Appeal Decision

Appeal Ref: APP/R5510/W/17/3190345

2 Worcester Road, Uxbridge UB8 3TH

- The appeal is made under section 78 of the Town and Country Planning Act 1990 against a refusal to grant planning permission.
 - The appeal is made by Mr P Shanahan (Greystoke Builders Limited) against the decision of the Council of the London Borough of Hillingdon.
 - The application Ref 35129/APP/2017/2264, dated 21 June 2017, was refused by notice dated 16 November 2017.
 - The development proposed is a new dwelling at side.
-

SECOND FLOOR PLAN

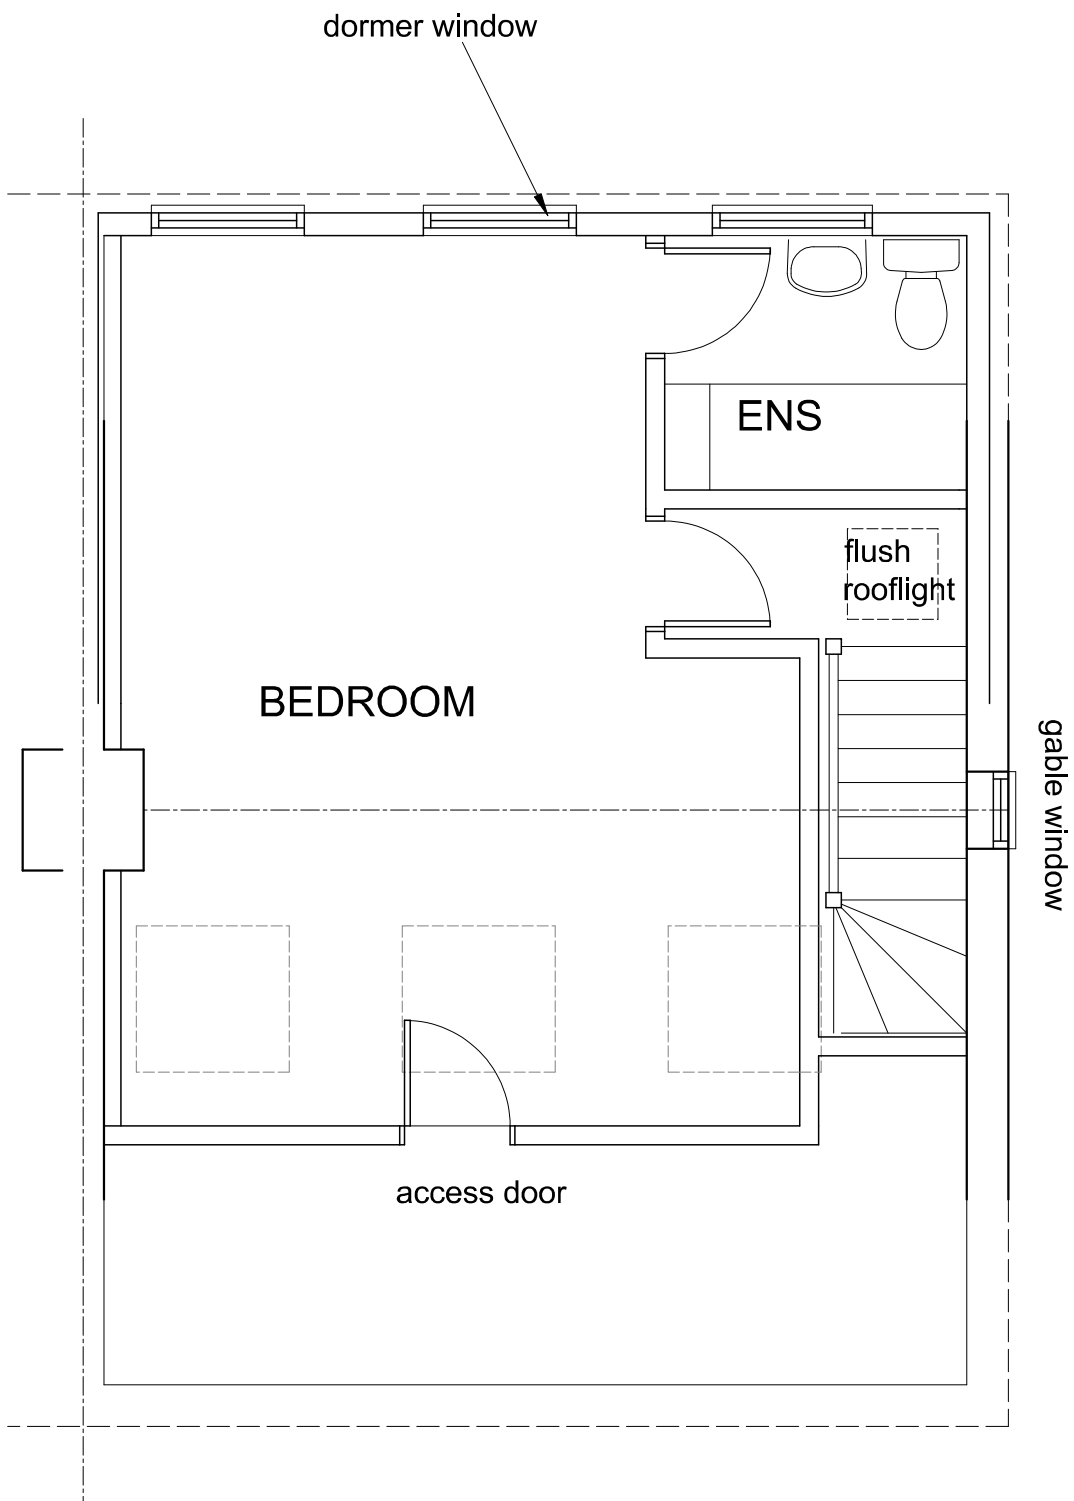
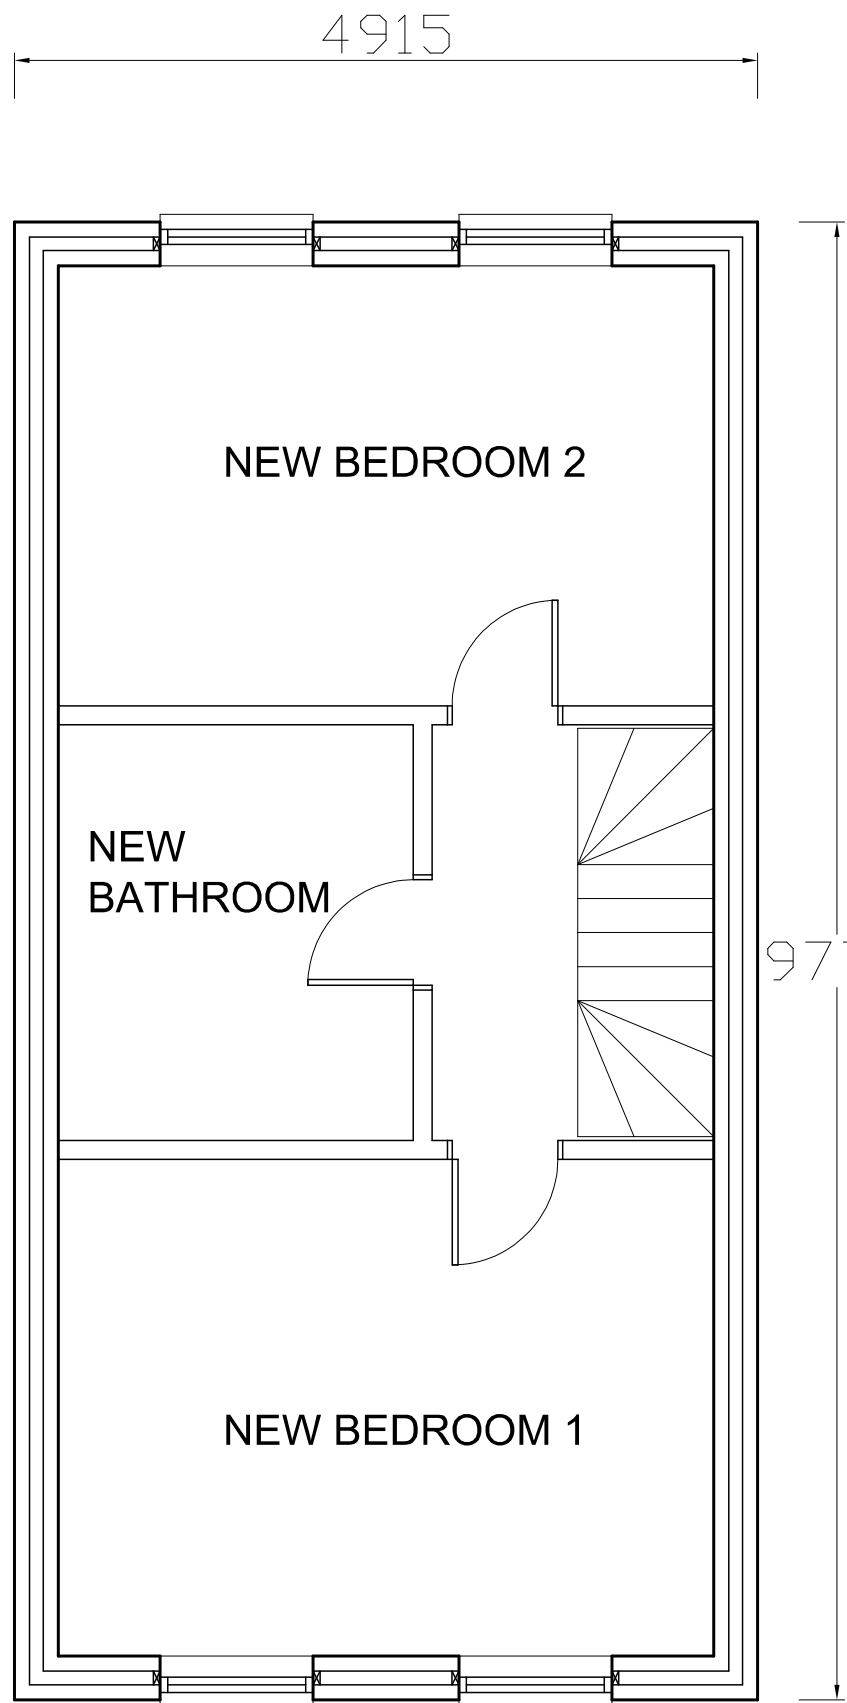
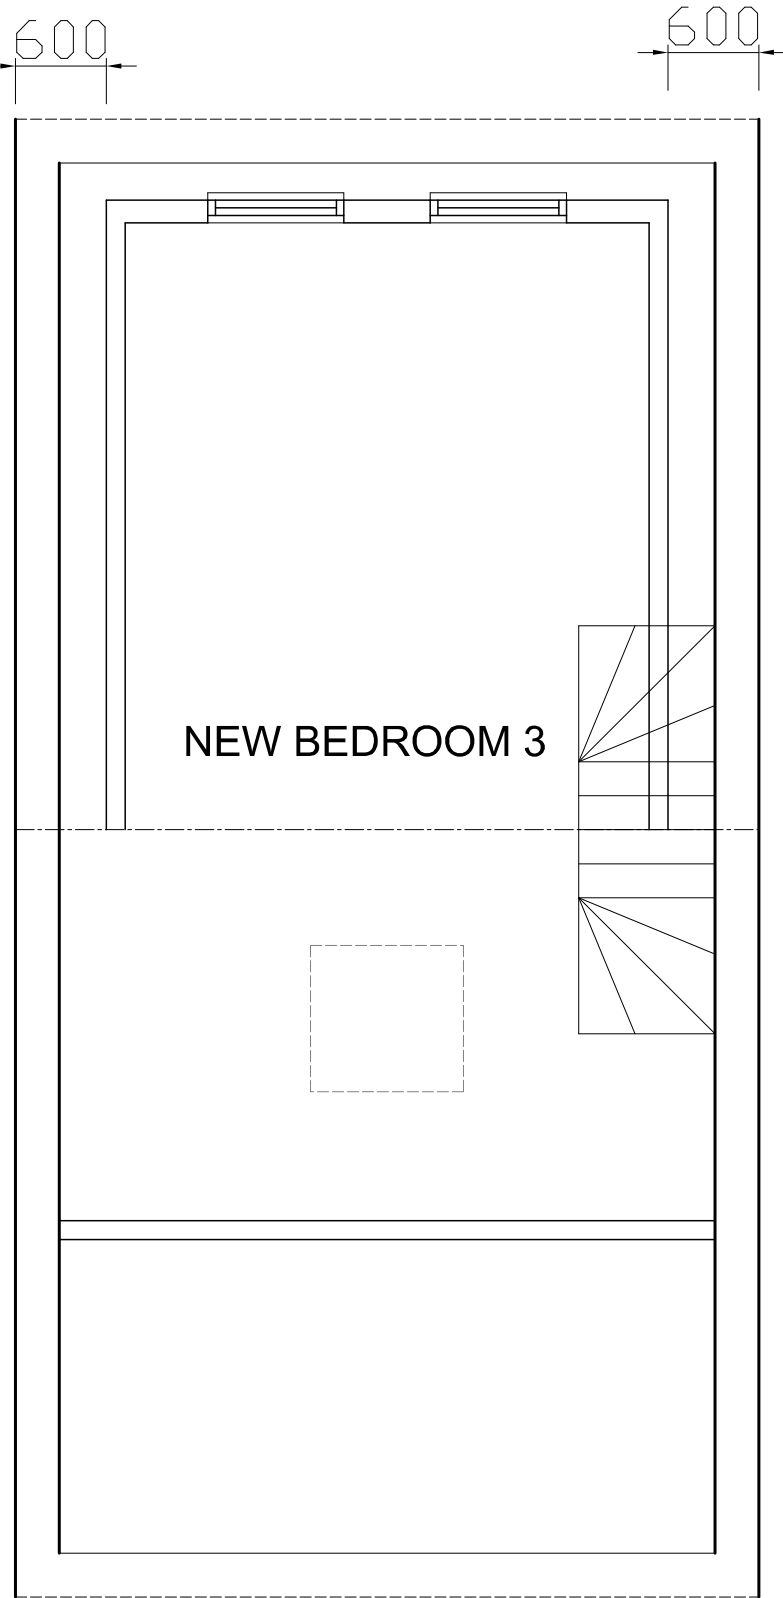
5. The proposed dwelling would also be set back from the front of No. 2, albeit not to the extent of the existing elements at the side of the host property. At the rear, it would extend beyond the rear of No. 2 and, whilst it would present

a longer flank elevation in a prominent position at the entrance to Worcester Road than that of the existing property, it would not be particularly noticeable or harmful.

7. Significantly however, the proposed dwelling's proportions would also fail to reflect the prevailing character and appearance of those of other properties within the street. Whilst it would reflect the heights of ground and first floor levels, and heights to eaves and ridge levels, of the adjacent pair of semi-detached dwellings, its width would be less than that of each half of that pair of semis. As a consequence, its width would appear somewhat compressed and its vertical proportions would overpower the horizontal. This would emphasise its limited width in comparison to the prevailing semi-detached and short terraced rows of houses and make it an incongruous feature at the entrance to the street.

8. Although the site of the proposed dwelling is largely occupied by a single storey garage and playroom extension to the side of No. 2, its overall scale, and particularly its height, is modest and it does not erode the regularity of spacing that I saw to be a consistent feature between properties along Worcester Road and Maygoods Green. In stark contrast however, the detached nature and form of the proposed dwelling, together with the limited spacing around and between it and No. 2, would sit uncomfortably with the relatively spacious, regular spacing between dwellings elsewhere along the street.

10. Although I do not find the flank elevation of the proposed dwelling to be particularly harmful, this does not overcome the concerns I have in other respects. Thus, I conclude that the proposal would fail to harmonise with the scale, form, proportions, character and appearance of other properties within Worcester Road and Maygoods Green. The proposal is therefore contrary to policy BE1 of the Hillingdon Local Plan: Part One – Strategic Policies (LP1), policies BE13, BE15 and BE19 of the Hillingdon Local Plan: Part Two – Saved UDP policies (LP2) and London Plan policies 3.5 and 7.4.

| Revision                                                                                                                                                                          | Description      | Date   |
|-----------------------------------------------------------------------------------------------------------------------------------------------------------------------------------|------------------|--------|
| Description: PROPOSED ELEVATION & BLOCK PLAN.                                                                                                                                     |                  |        |

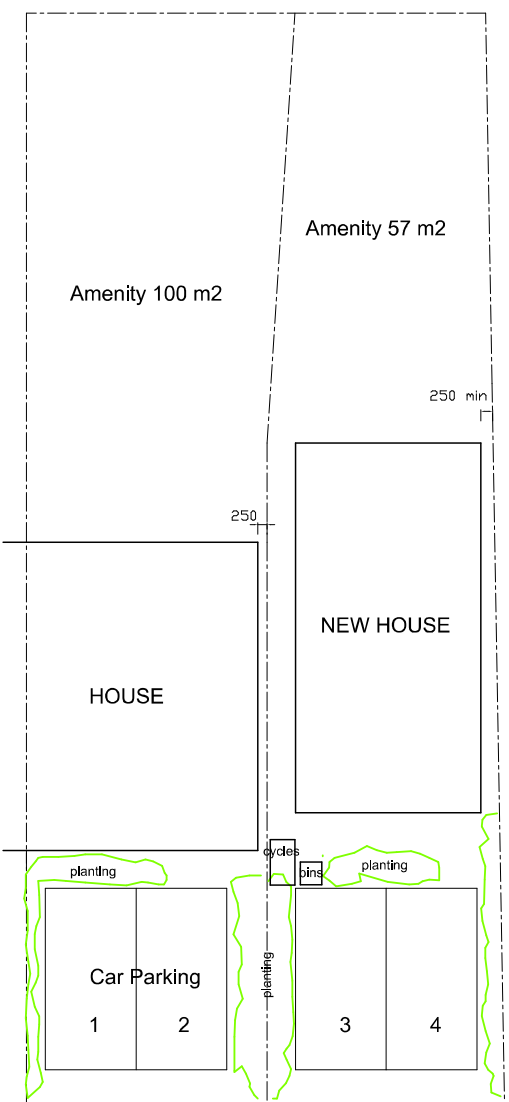
11. Although the proposed dwelling would extend beyond the rear face of No. 2 the Council accept that it would not breach the 45° principle set out in the Hillingdon Design and Accessibility Statement (HDAS) Supplementary Planning Document. Furthermore, whilst the Council also consider the proposal to be too close to the flank elevation of No. 2, they have not sought to dispute the

appellant's assertion that the proposed dwelling would instead, and in accordance with LP2 policy BE22, be set apart from No. 2 by 1 metre.

12. The rear of the host property faces due south and has a relatively open outlook over a reasonably generous rear garden and the school grounds beyond. Whilst the additional rearward projection and flank elevation of the proposed dwelling may result in some afternoon overshadowing, the nature of the surrounding ground levels and properties to the west on Elliott Close, are such that these are likely to be as significant factors affecting afternoon sunlight as the proposed dwelling would. Whilst the 45° principle is merely a guide, the proposal's adherence to this principle supports my conclusion that the proposed dwelling would not cause unacceptable or material harm to the living conditions of occupiers of the host property in terms of sunlight or daylight.

13. Furthermore, the Council have not supported their contention that the proposed dwelling would be 'too close' to No. 2 or sought to challenge the appellant's statement that it would be set apart from No. 2 by 1 metre. In any event, it seems to me that in terms of the spacing between dwellings and plot boundaries, LP2 policy BE22 is concerned more with the effects of the loss of spaces between dwellings upon the character and appearance of an area rather than the living conditions of occupiers of adjacent dwellings.
